Re: Stack Short Plat (SP22006)

Thank you for your preliminary short subdivision submittal. After technical review of the proposed short subdivision, the Planning Division offers the following comments:

RE: Stack Short Plat, File# SP22-006
5 Lot Short Plan
3807 122nd Street NE & Parcel # 30050900202200

STACK DESIGN & CONSTRUCTION, LLC
STACK SHORT PLAT
 PRELIMINARY ROAD, GRADING AND STORM DRAINAGE PLAN

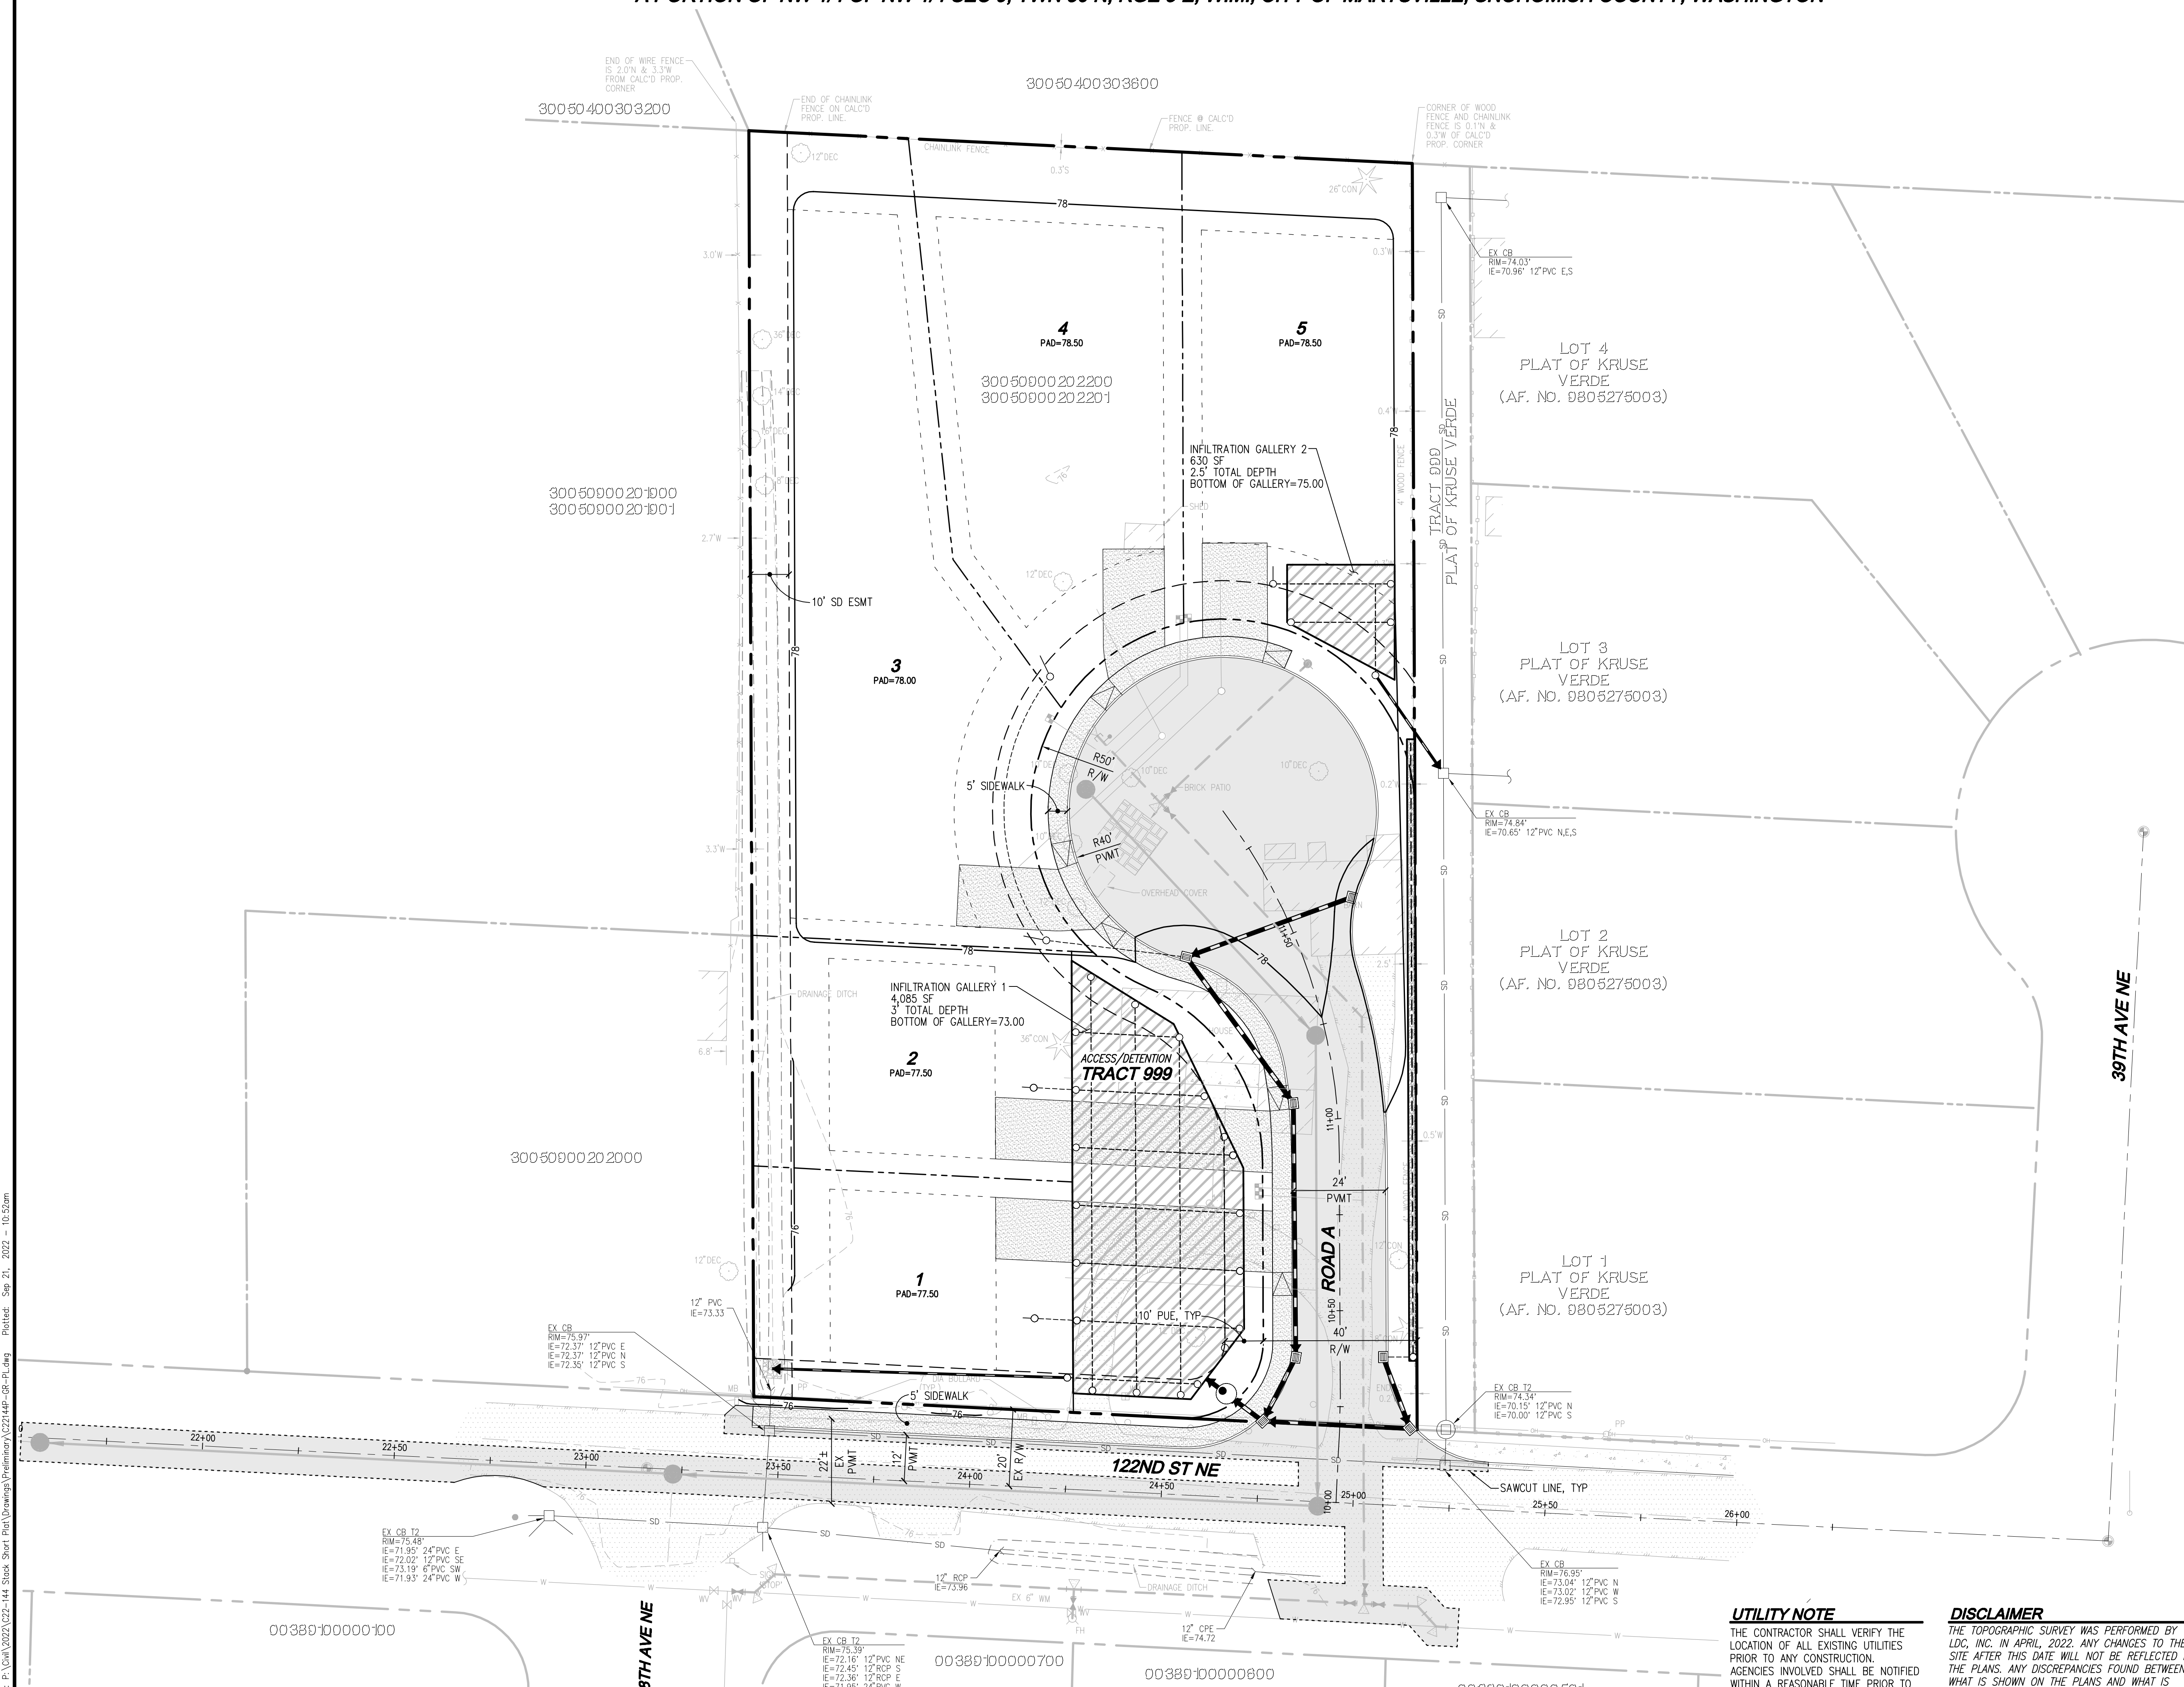
9. The sidewalk along 122nd Street NE needs to match the sidewalk to the east. Amend the plans to show 6 feet of sidewalk adjacent to the curb. See comments from Shane Whitney.

- In the narrative of the drainage analysis, it was noted that pervious pavement was going to be used. I'm not seeing in the rest of the materials that it is planned for, please revise.

8. The sewer alignment shown at the end of the cul-de-sac won't work. We can't have cleanouts in the street. The last manhole will need to swing over to the east.
